**Tweed Shire Council comments on the proposed North Byron
Parklands Cultural Event Site (SSD 8169) and modification of the
Concept Plan (MP09_0028 Mod 5)**

I refer to your email of 12 December 2017 requesting Council's comments in relation to the proposed SSD and Concept Plan Mod 5 for the North Byron Parklands Cultural Event Site at Yelgun.

Figure 4.2 Site access gates A, B, C, D and E

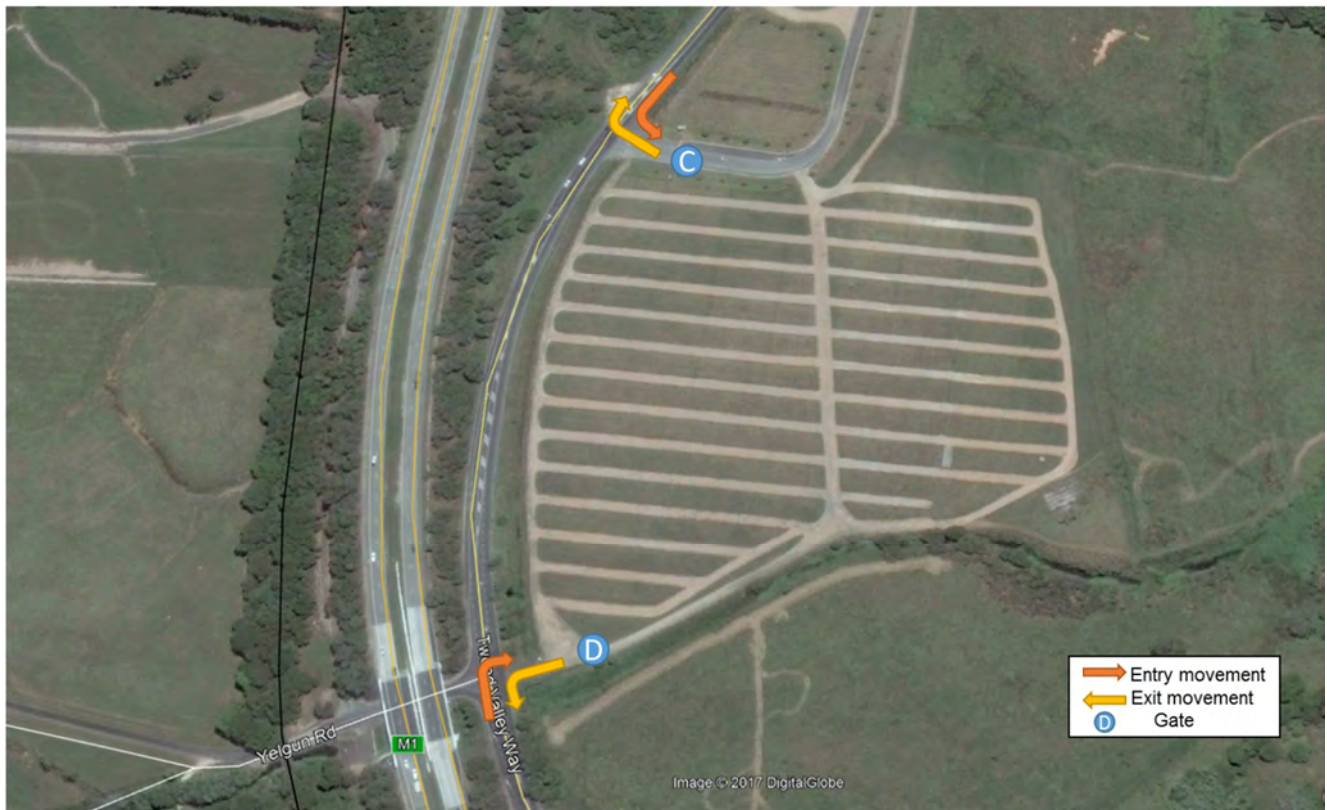
- a. The proposal is not very clear in the proposed use of the access road onto Wooyung Road. The EIS makes reference to it as the existing "Emergency Access Road", but also makes reference to it as an access road to service the Tweed Coast catchment. The Traffic Assessment associated with the SSD is clearer in terms of the proposed change of use of the access road.

- b. The proposed use of Gate E was considered by the Traffic Assessment to be less than when the access was used as an emergency access road for previous events under police direction. The methodology used to estimate traffic generation (by postcode) is not accepted by Tweed Shire Council as providing a realistic estimate of the potential traffic volume utilising Gate E for access / egress purposes. Event patrons from Brisbane could use the Gate should queue lengths at other gates become excessive and there is no guarantee that camping spaces will be allocated to Patrons from the Tweed Coast area.

- c. It is considered appropriate that traffic modelling should be carried out on the maximum patronage and attendee's model.
- d. The Traffic Assessment provides limited information on any road upgrades required to facilitate the proposed access / egress point at Gate E and the potential impact upon the Tweed Coast local road network.

- e. The proposed driveway access for Gate E is to be constructed to Council's requirements, catering for the expected peak movements, is subject to an approval from Tweed Shire Council under s138 Roads Act. It is recommended that any consent be conditioned accordingly.

- f. The Traffic Management Plans associated with the Traffic Assessment do not include the Wooyung Road entry / exit point (Gate E).
- g. The EIS does not provide any details on the proposed works associated with the access road, apart from noting that it will be constructed above the Q100. This is not considered to be necessary given that Wooyung Road is subject to flooding in the Q100 and cannot be relied upon for emergency access during times of flood. However, it is considered that additional information is required with regard to potential impact associated with the proposed upgrade of the access road to the North (Gate E). It is recommended that further detail be provided in terms of the details for the access road, culverts etc and potential flood modelling required to determine impact (if any) on the adjoining allotments as a result of the proposed access road.

Figure 17: External Road Low Points

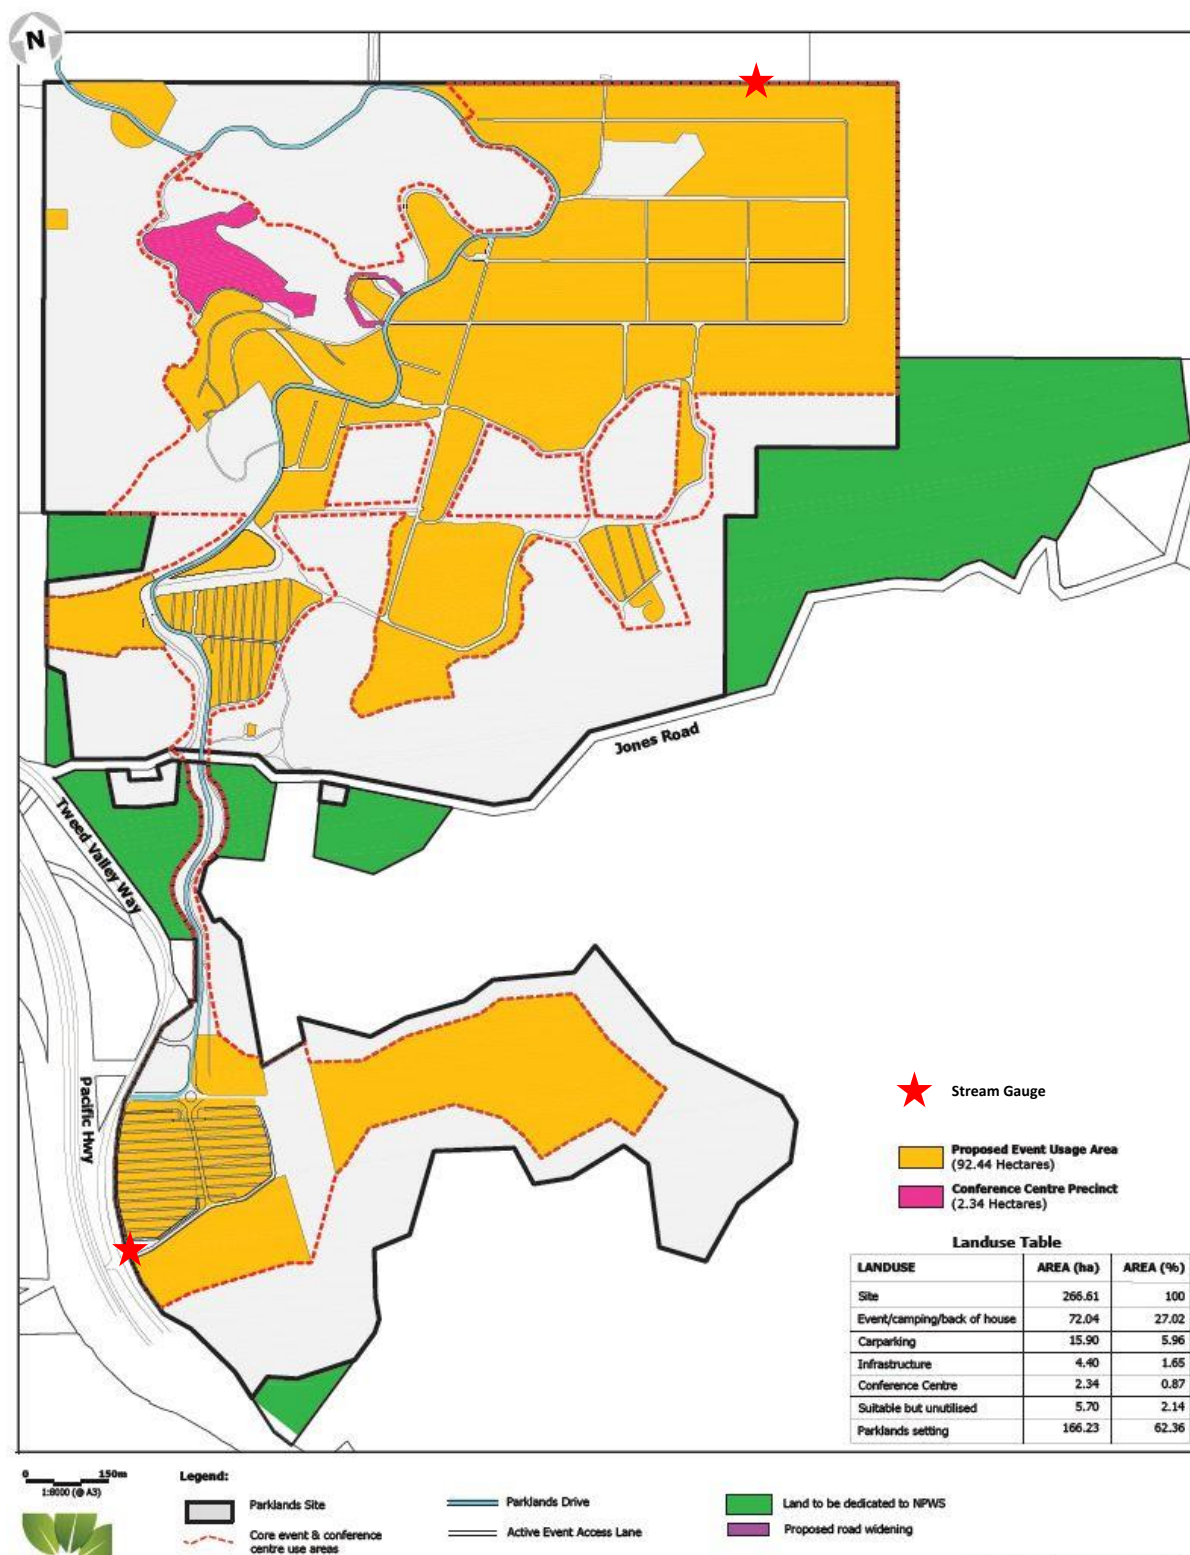
- d. The FRMP notes that the access road to the north be upgraded to be above 1:100 ARI to allow access to Wooyung Road. Further to the Traffic comments above, it should be noted that Wooyung Road has several low points, which are flood prone in 1:5 ARI events, let alone 1:100 ARI events.

Figure 19: Flood Emergency Assembly Area

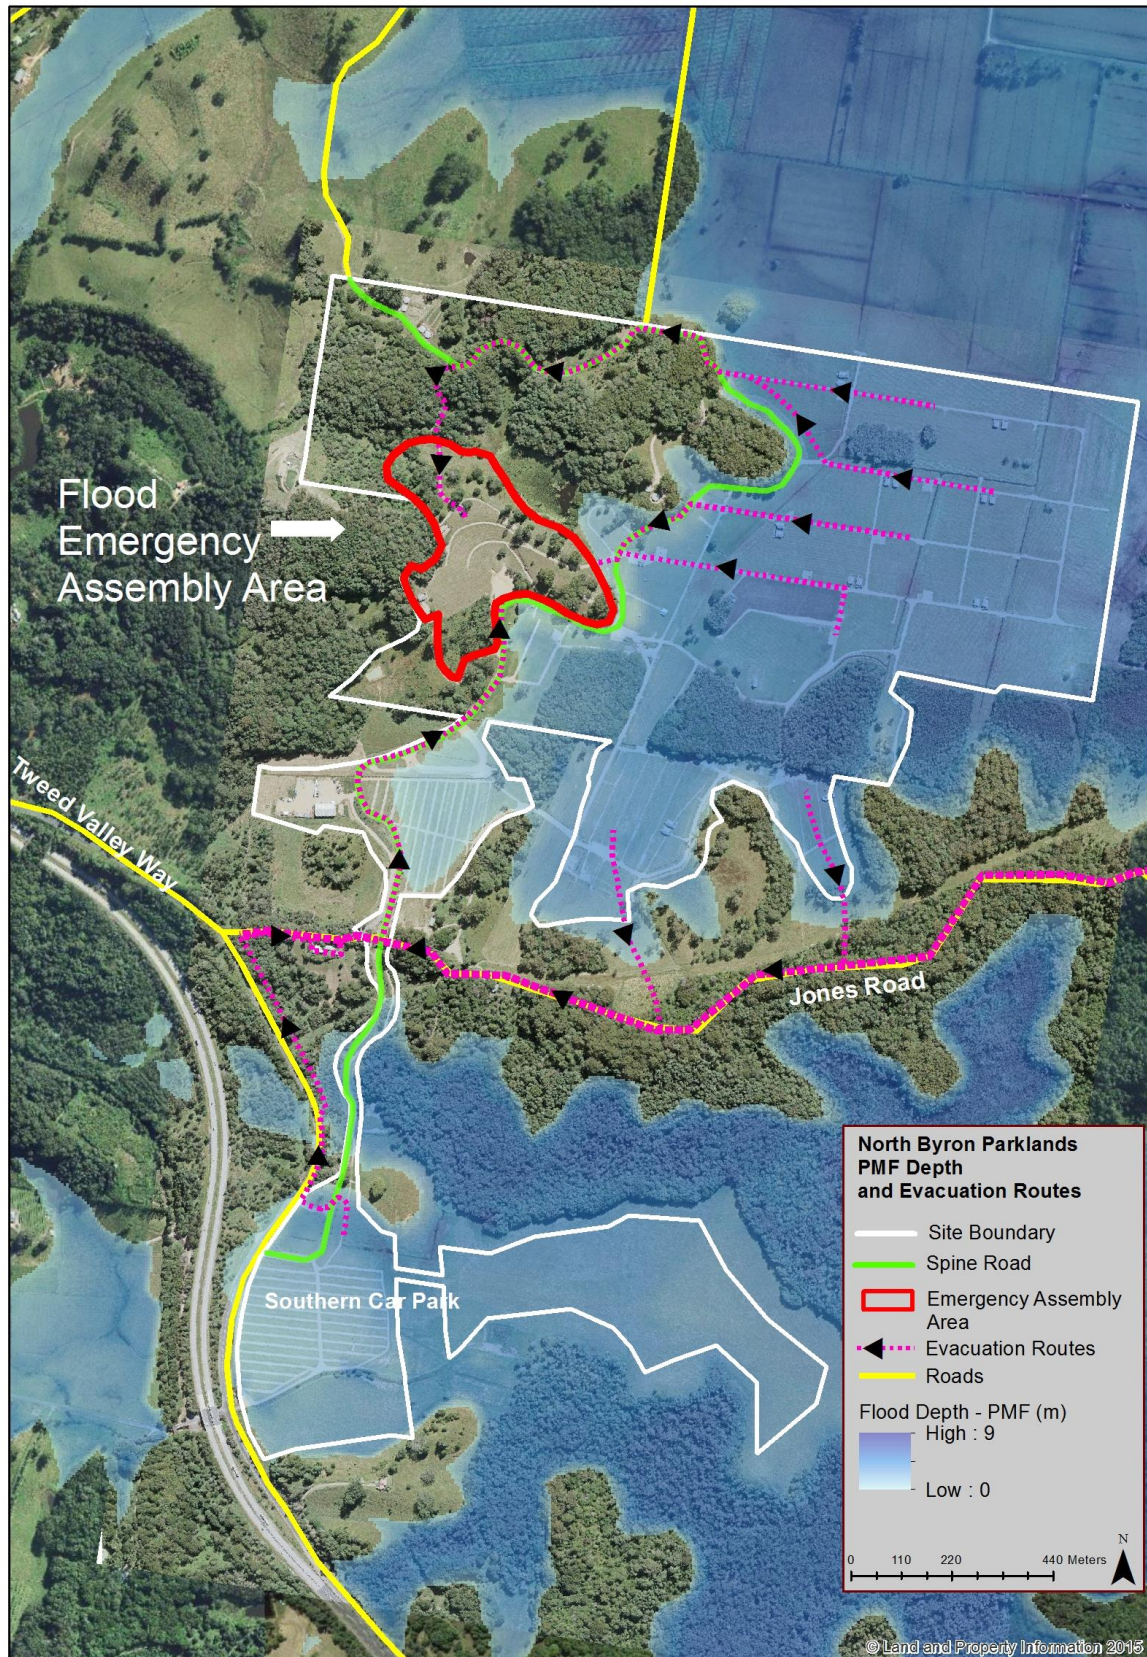
- b. There are several concerns with the proposed evacuation routes and the Primary Assembly Area to the north of the main event site, these being:
- i. The BEEP notes that safe egress to the Primary Assembly Area to the north of the camping area is less than one hour, based on pedestrian modelling. The BEEP does not appear to have taken into consideration weather conditions which would make evacuation to the assembly point unlikely (i.e. smoke impacts from a bushfire etc);

- h. The Bushfire Assessment report incorporates several northern adjoining allotments (Lot 11 DP1192842 and Lot 4 DP821947) for use as the Primary Assembly Area. Concern is raised with regard to the need for a potential alternate assembly area should owners consent no longer be granted for Lot 11 and Lot 4.
